Re: Savio Ridge Subdivision at 1600 Arroyo Vista Blvd. NW Erosion and Sediment Control Plan Engineer's Stamp Date: 5/23/25 (J08E003B & SWQ-2025-00028)

Based on the information in your submittal, received on 5/23/25, the ESC Plan and Notice of Intent (NOI) can't be approved for Grading, Work Order, or Building Permits until the following comments are addressed.

ESC-1

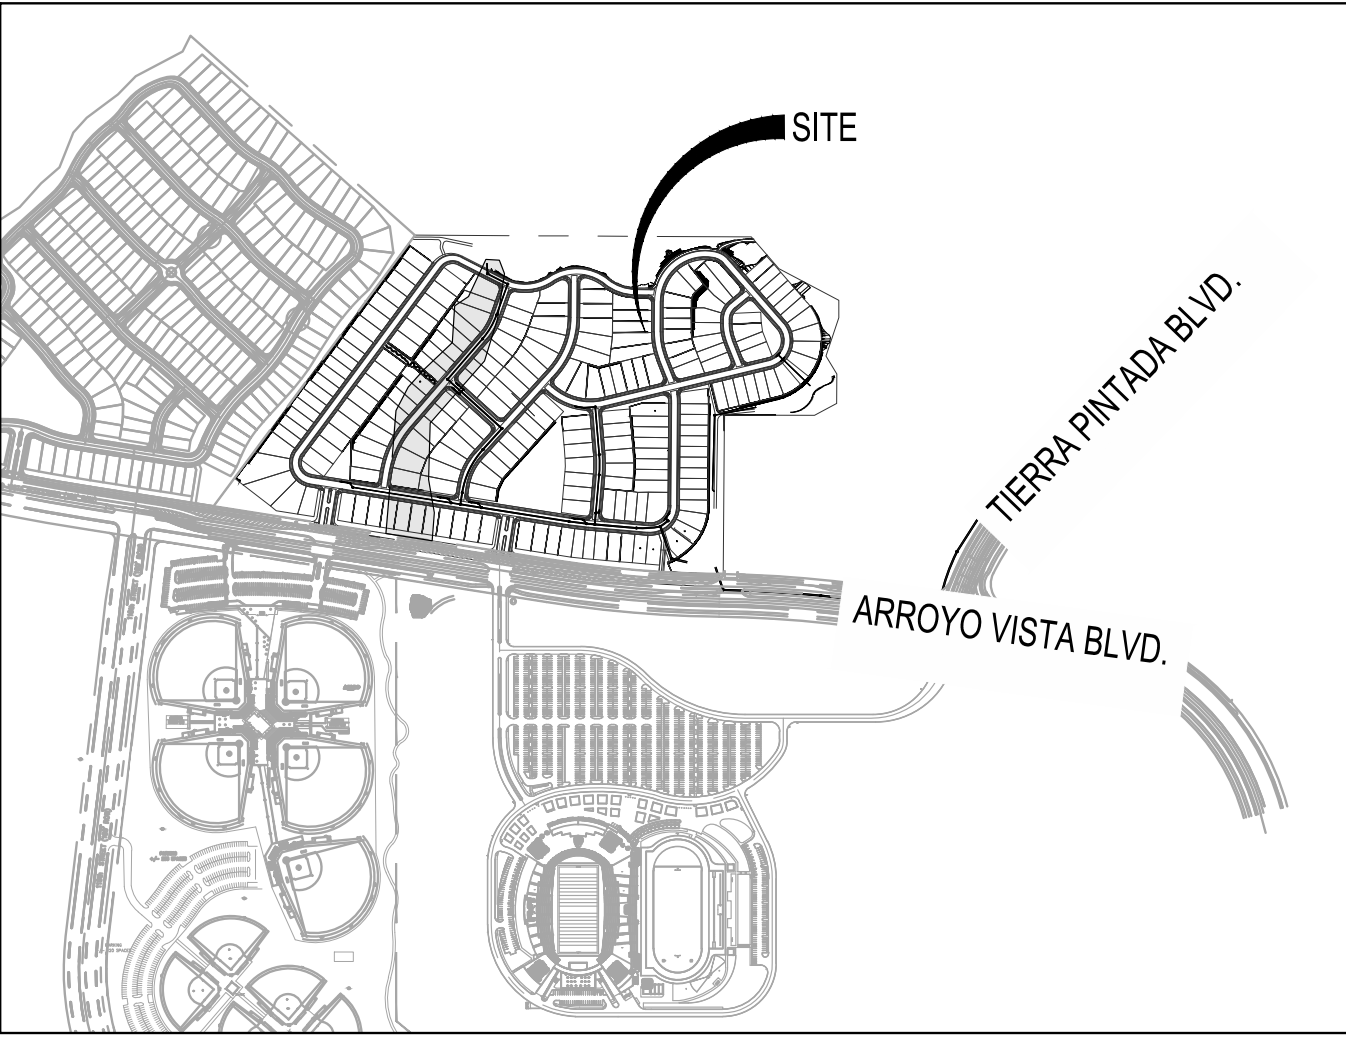
- 1. The 60-acre area of land disturbance shown on the ESC Plan only includes the onsite portion of this project, and it appears to be mislabeled as 108 acres on both the ESC Plan and the NOI. The off-site portion of this project must also be included in this ESC Plan, along with the corresponding temporary controls and Best Management Practices (BMPs). Additionally, the total area of land disturbance must be corrected on the ESC Plan and NOI.

- 2. Identify the existing drainage patterns per CGP 7.2.4.f, especially the "Discharge Points" where concentrated flow enters and exits the disturbed area, and identify the temporary Best Management Practices (BMPs) that will prevent discharge into the city's "Municipal Separate Storm Sewer System" (MS4) before the "Commencement of Construction Activities." as defined in Appendix 'A' of the CGP. Also, identify existing storm sewers that will be removed, including the timing and method of removal.

- 4. The Phase 1 temporary ponds and berms are not clearly shown on the ESC Plan. They must be clearly identified as temporary BMPs to differentiate them from the permanent ponds shown on the G&D Plan.

ESC POND VOLUME EXHIBIT

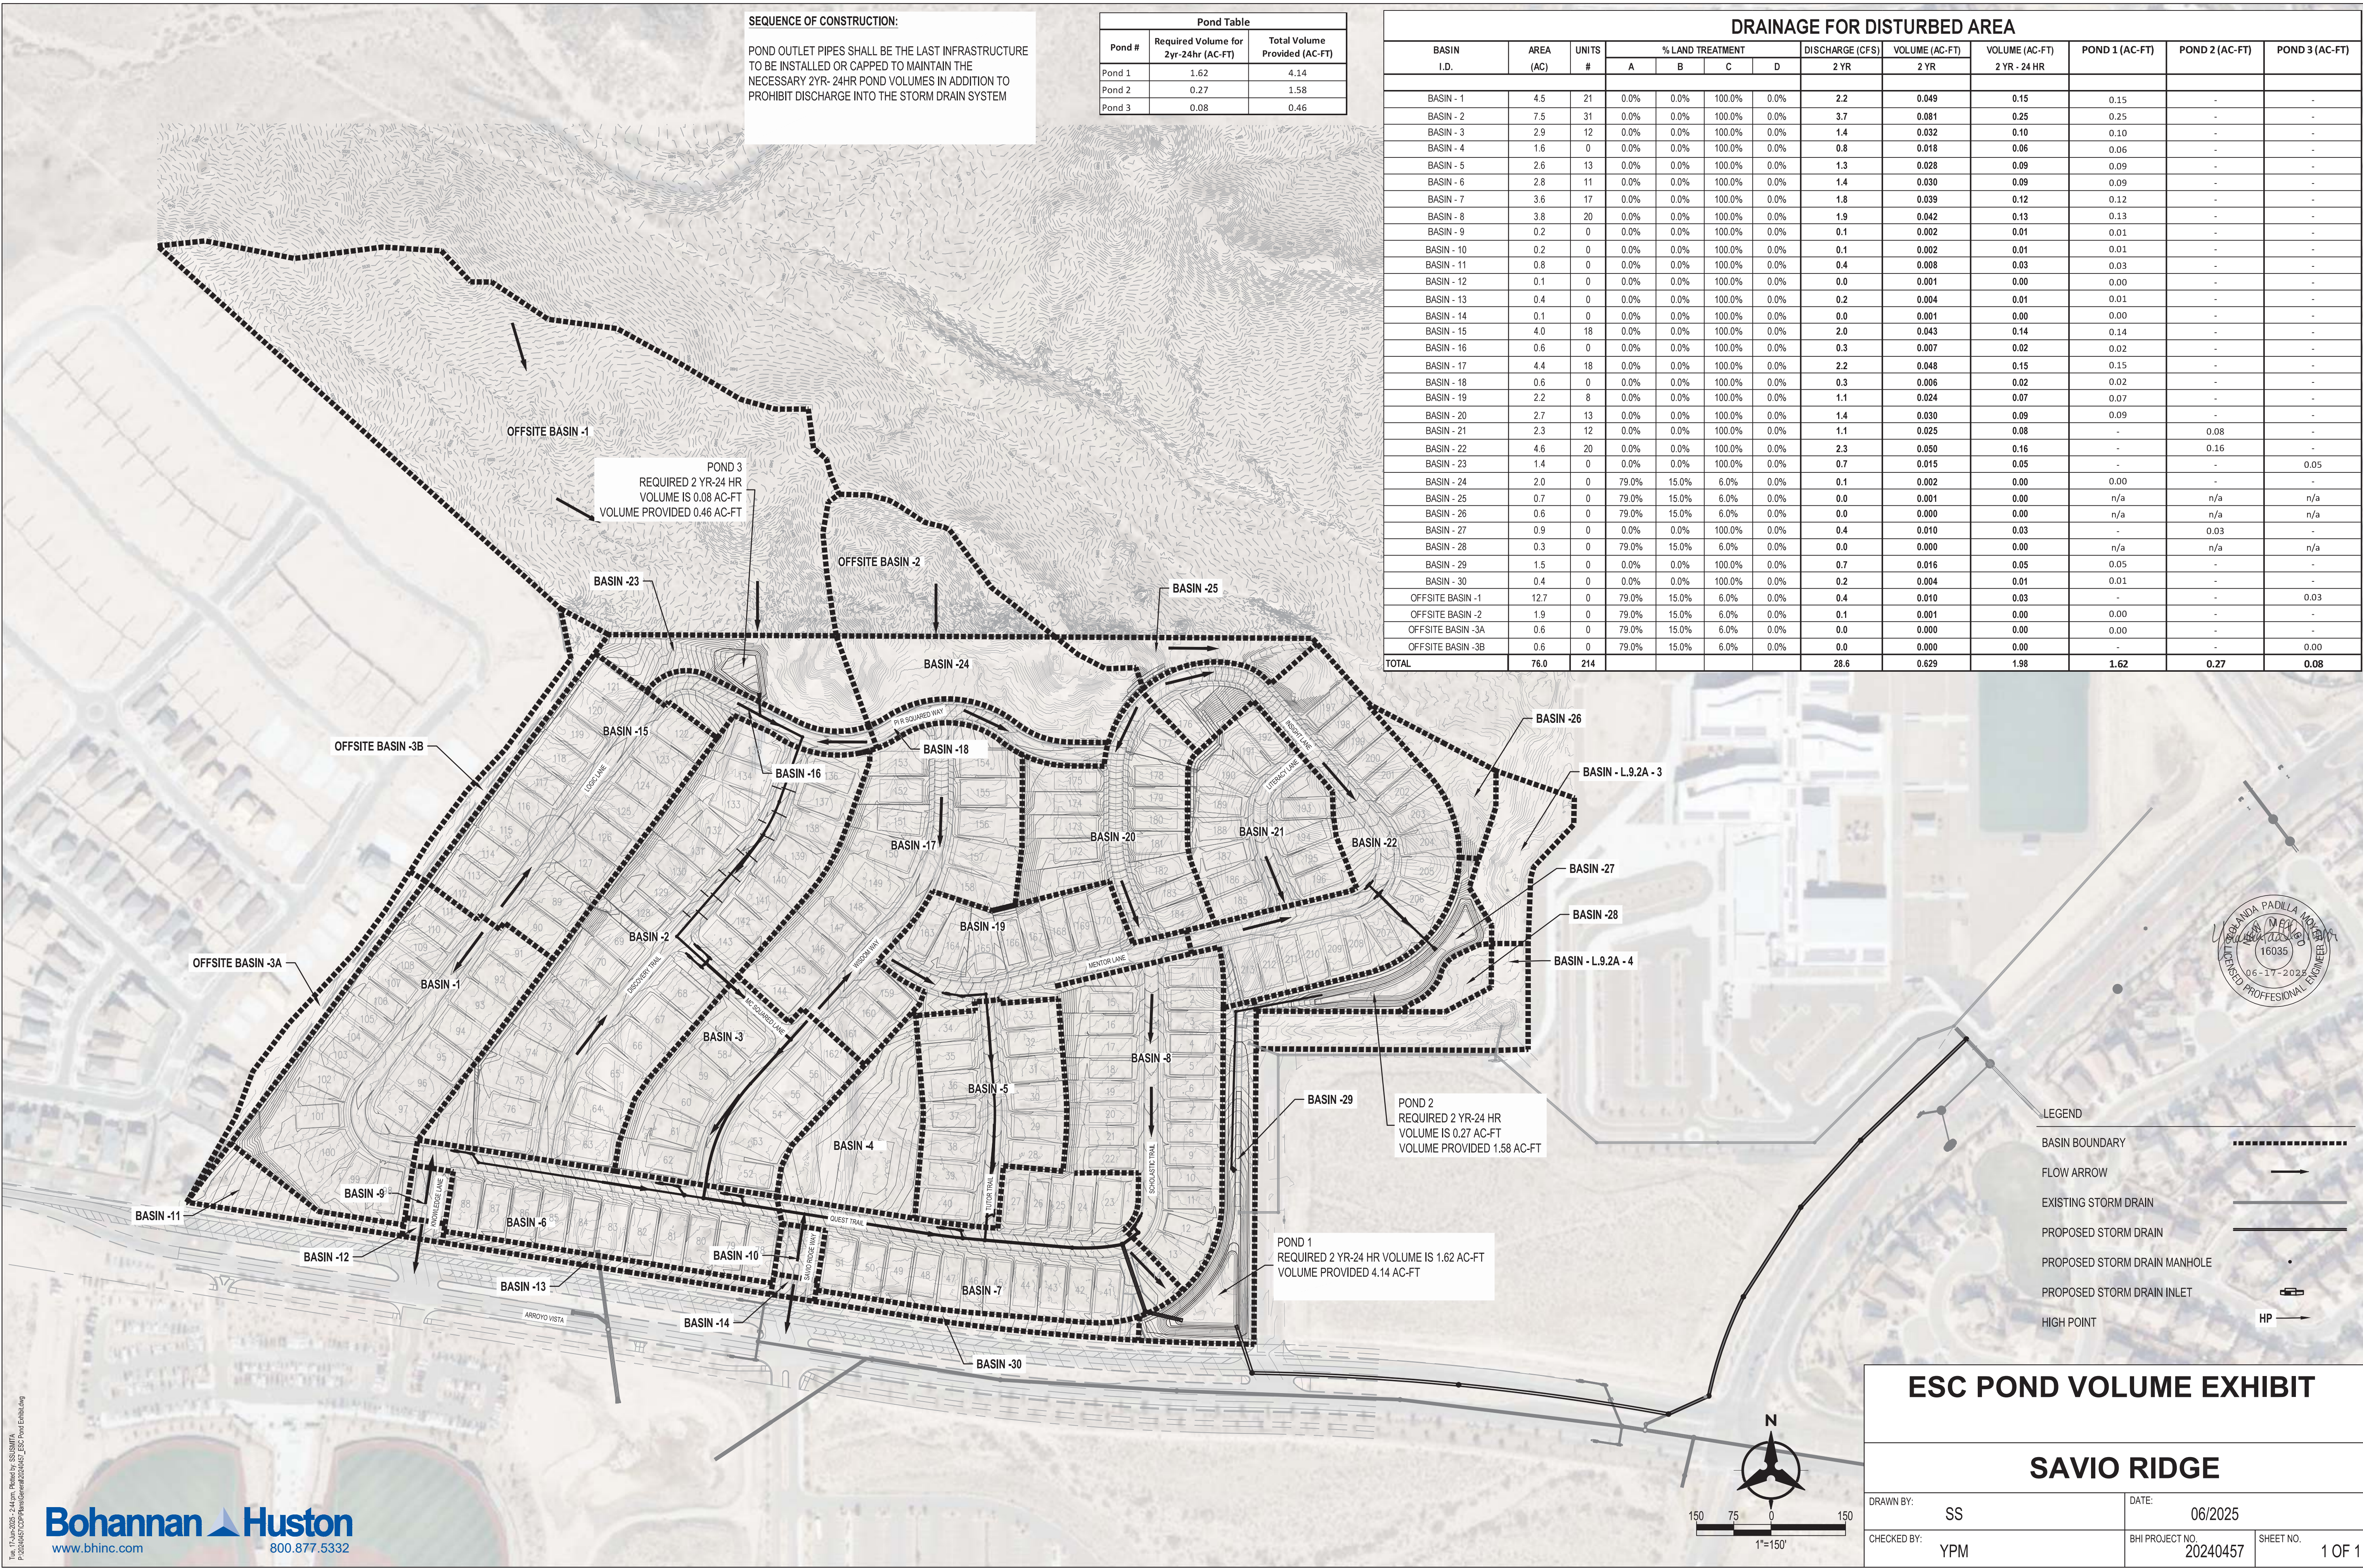
- 5. The sediment basin design calculations, per CGP 2.2.12.c, and construction specifications, per CGP 9.6.1.c.i, are missing from the ESC Plan and must be included with a professional engineer's certification. Capacity calculations and details must also be provided for the temporary outfall structures per CGP 2.2.12.d. Construction details and specifications are required in accordance with good engineering practices, as outlined in CGP 2.1. Use erosion controls and velocity dissipation devices to prevent erosion at inlets and outlets, as specified in CGP 2.2.12.e.
